FILE NO: PPR-20-014

AT&T SITE NAME:
CALHAN

AT&T SITE NUMBER:
COL02031

SITE ADDRESS:
**11594 HAHN ROAD
CALHAN, CO 80808**

SHEET NUMBER:
C-1.1

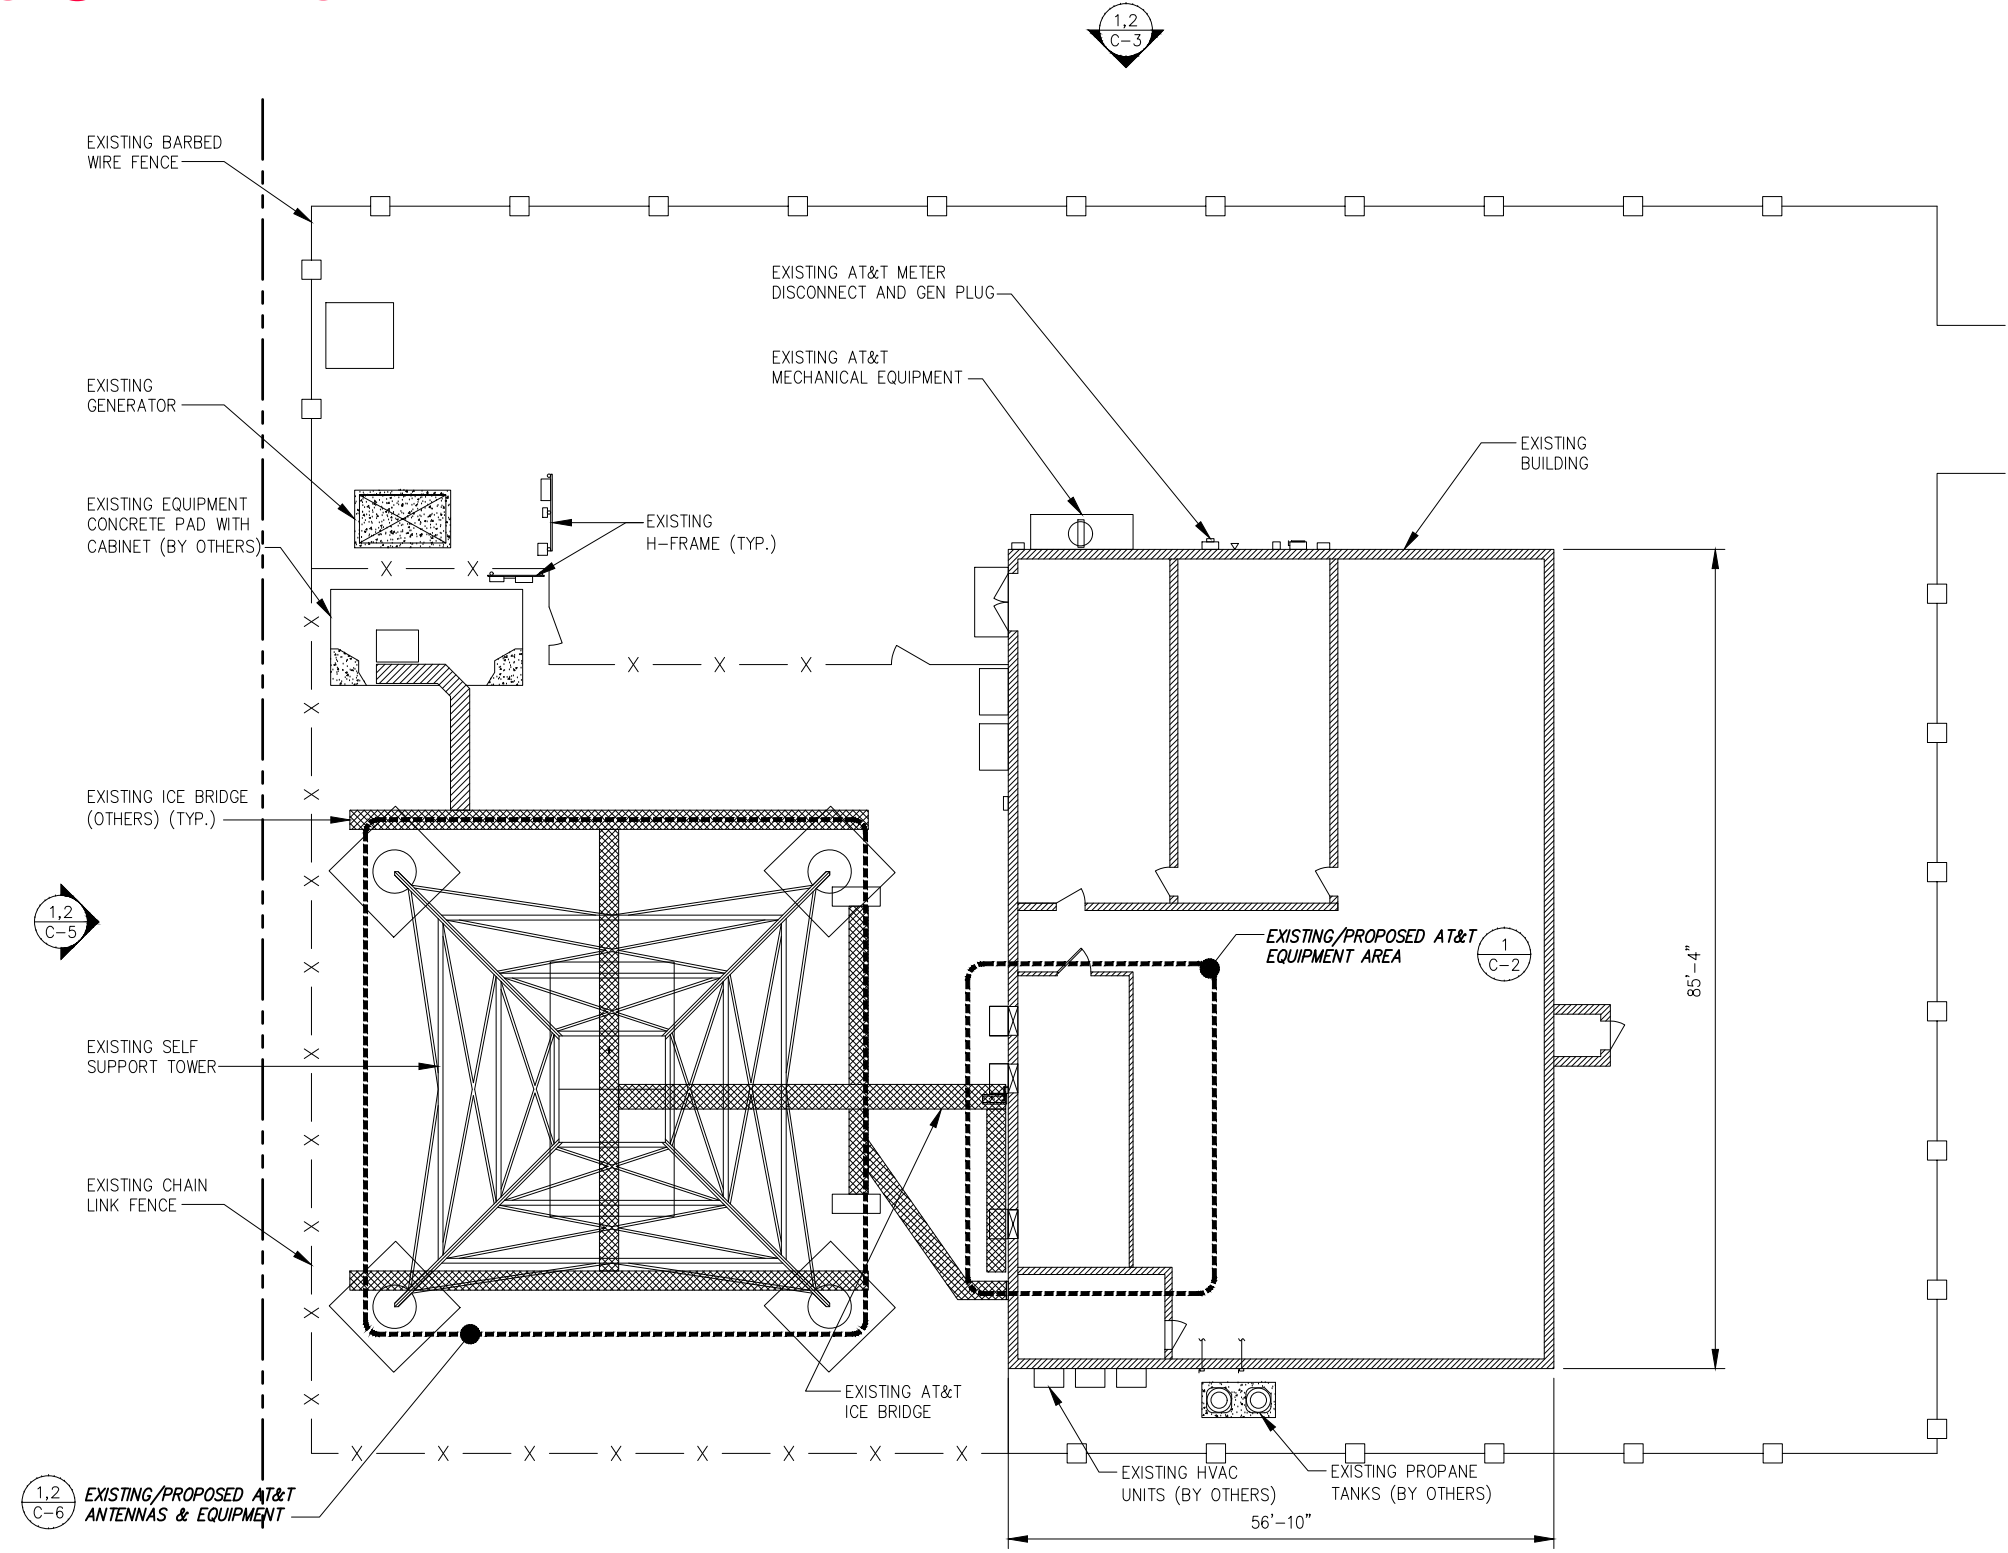
Please clarify what is existing and what is proposed. If equipment is being installed on the ground, a construction detail must be included and the equipment/structures must be completely screened by 100% opaque screening. Please give a construction detail of the screening technique used. vinyl and chain-link is not an acceptable screening technique.

Confirm address. El Paso county tax assessors office has this location addressed as 11598 Hahn Road
